Re: **Proposed: Northbank Enterprise Hub MP 10_0153**
Property: LOT: 1001 DP: 1127780
365 Tomago Road TOMAGO

Reference is made to the Department's letter dated 10 September 2011 requesting comments on the Environmental Assessment (EA) of the above project. Council has previously provided comments on the proposal in letter's dated 4 February 2011, 22 March 2011 and 2 February 2012. Council has significant concerns with the application which are discussed in detail below.

Figure 7-1 Post Development Scenario (Partial Flood Bund) - 1 in 100 Year Flood Depths

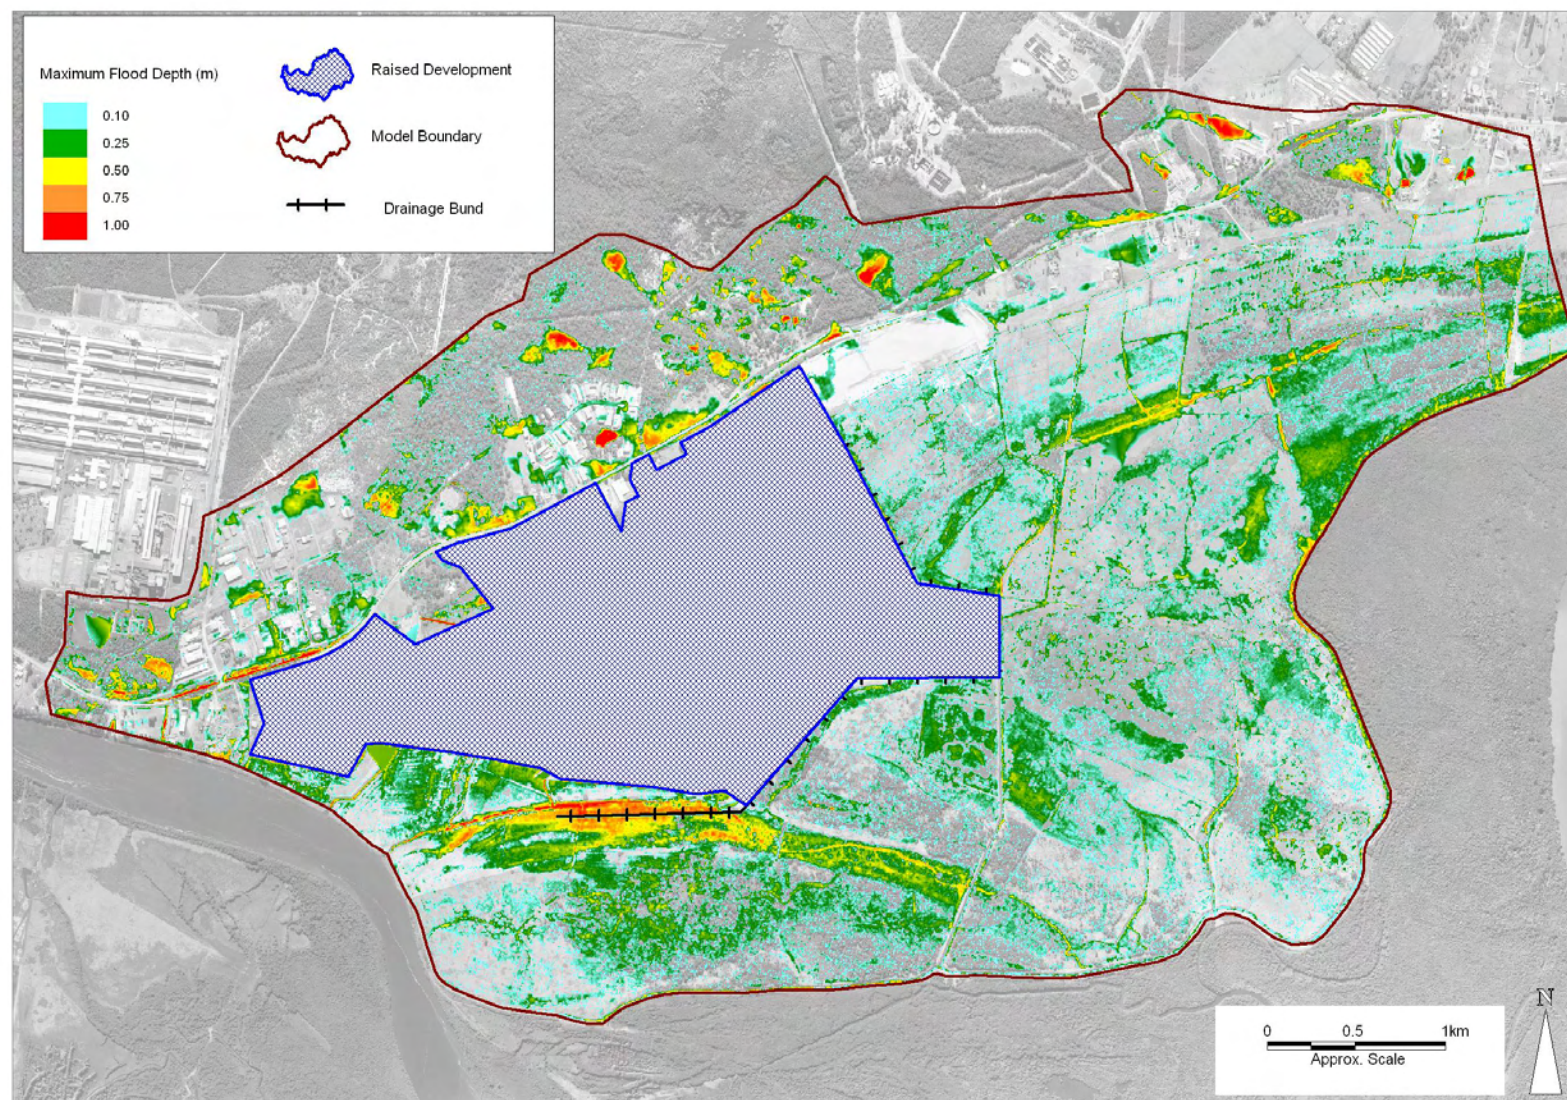
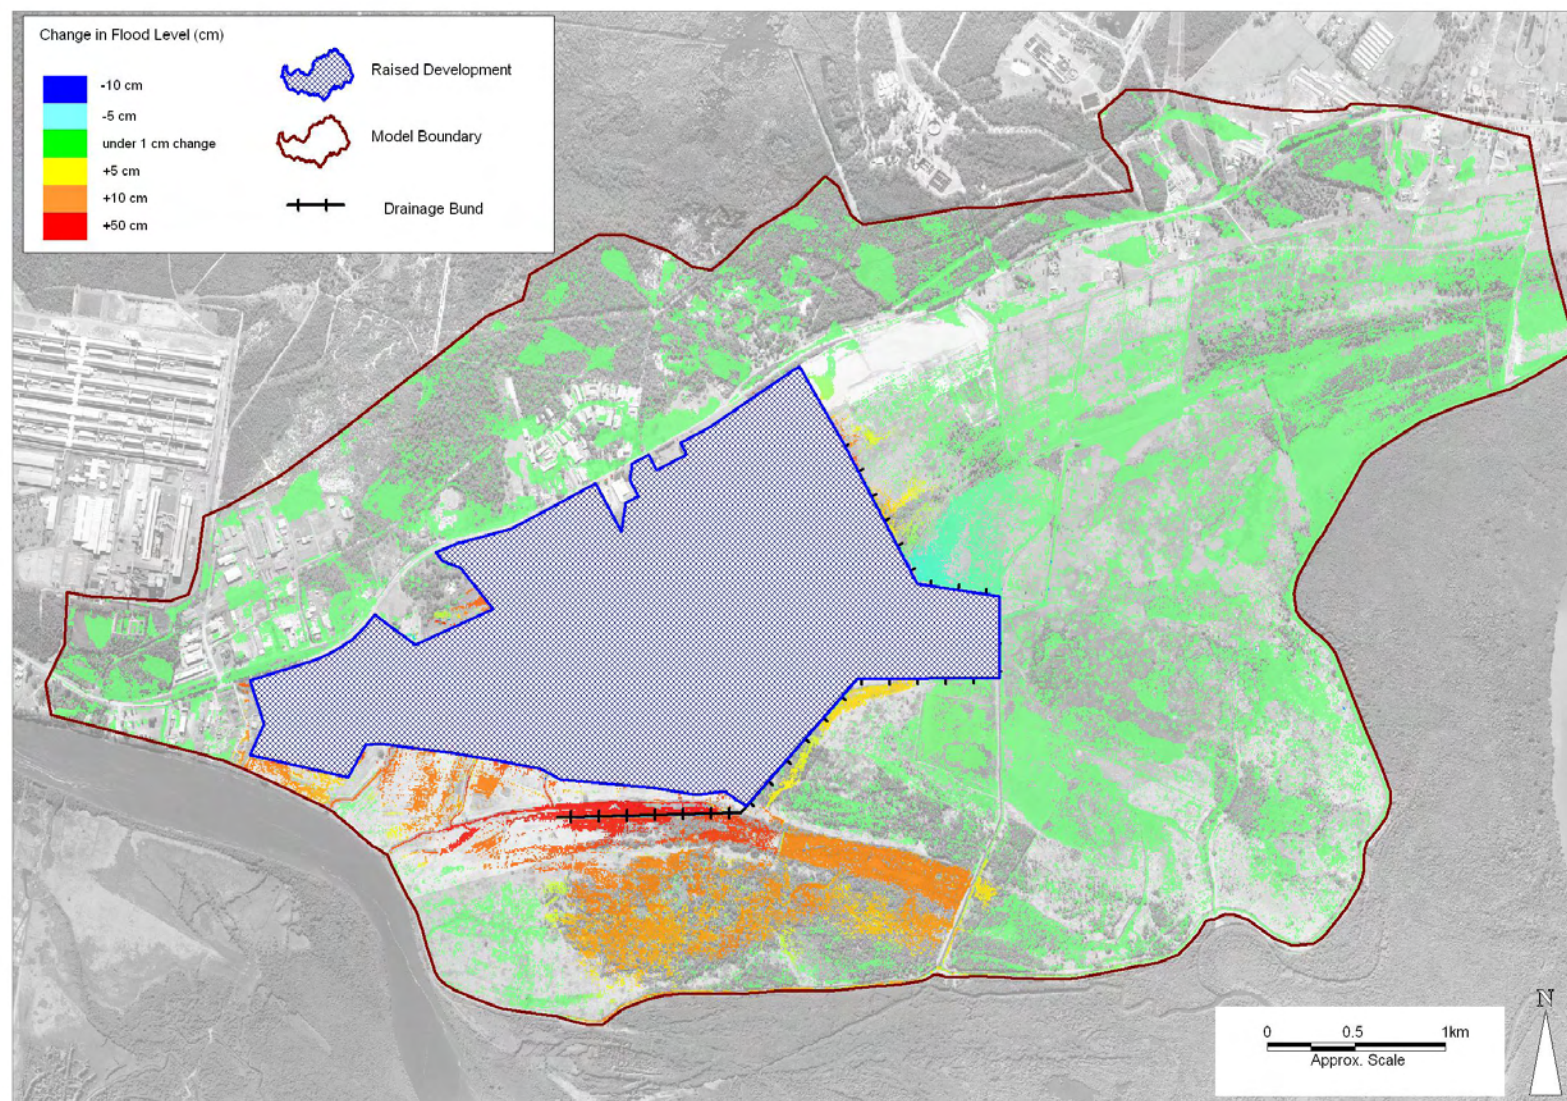
1. The flood study has determined that the flood impacts will be up to 0.18 m adjacent to the development. This is an impact that needs to be investigated further rather than be covered by a statement that individual bunding will protect dwellings. Properties in this area are currently rural and the impact of increased flooding frequency on adjacent land may have an impact on the viability of the properties. The other issue is that the report does not indicate what bunding is proposed to protect properties and whether it is to be located on development land or private land. Therefore the flood impact assessment should provide more specific details of proposed bunding and assess the impact of the flooding on likely affected properties such as 139, 159 & 175 Cabbage Tree Road from a land use viability perspective as well as the flood risk to buildings.

3. The report identified that the proposed development would increase the peak flood level of up to 0.18m adjacent to the development footprint. It is not clear that the area of development footprint has included the existing Westrac development or not. If it is not, it must be included in the modelling and cumulative increase of water level must be simulated immediately adjacent to the development area. This level may be more than 0.18m.

Figure:
6-6

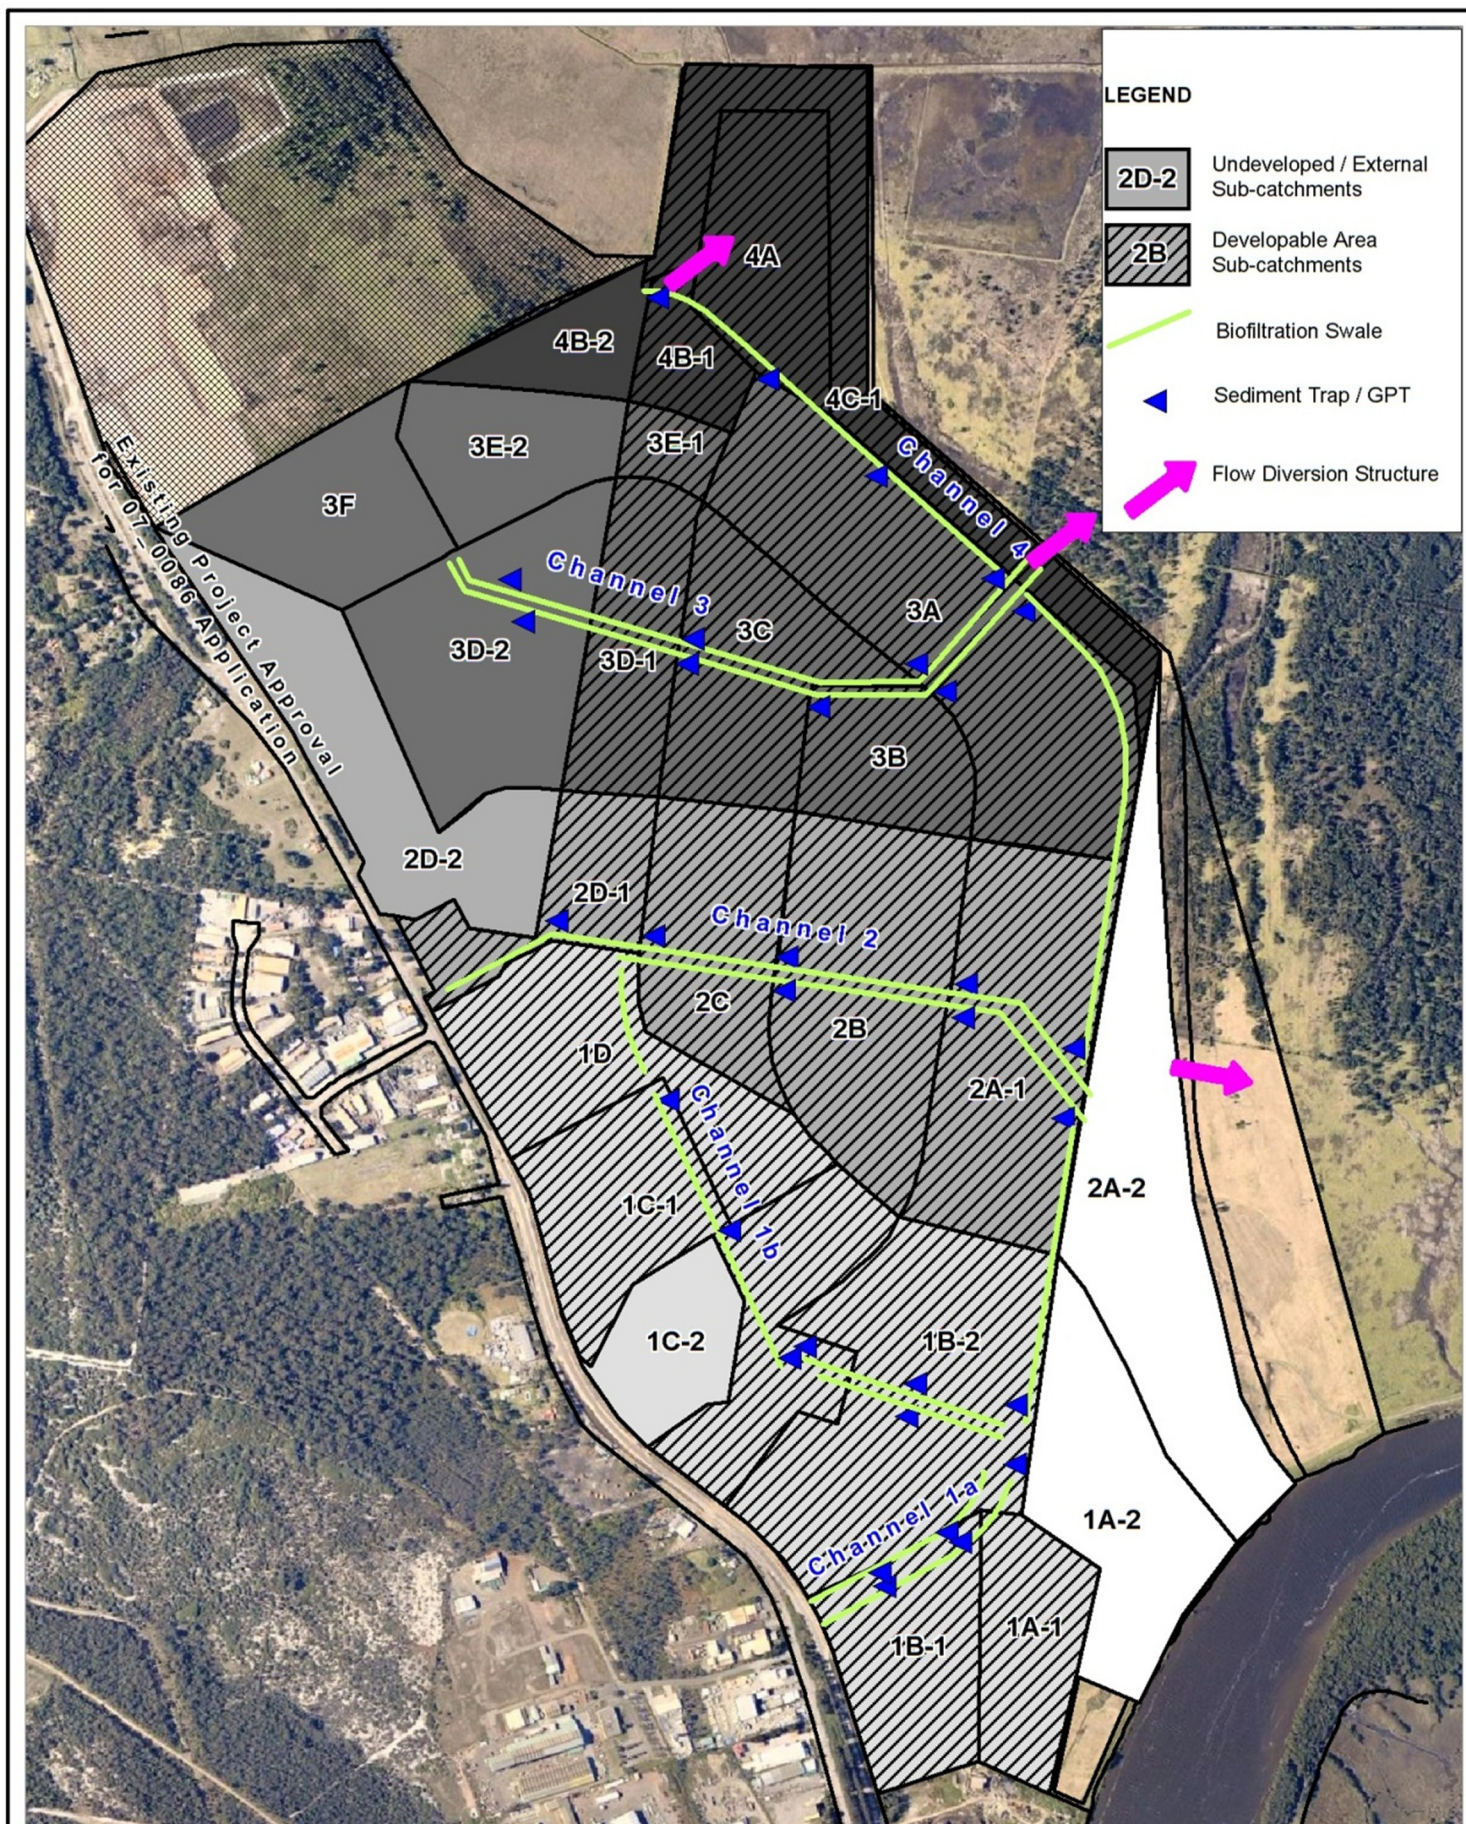
Normally subdivisions have enough fall that they can grade stormwater systems to centralised locations to optimise the number of systems to be serviced. This site is so flat that this is unable to be designed and thus drainage structures are fragmented into dozens of small systems that become uneconomical to maintain. An example of this is the number of GPT's (32 are proposed) whilst the same scale development on a 3-4% slope would have 8 or less. The same can be said for the 8km of biofiltration swales that are shown in Fig6-6.
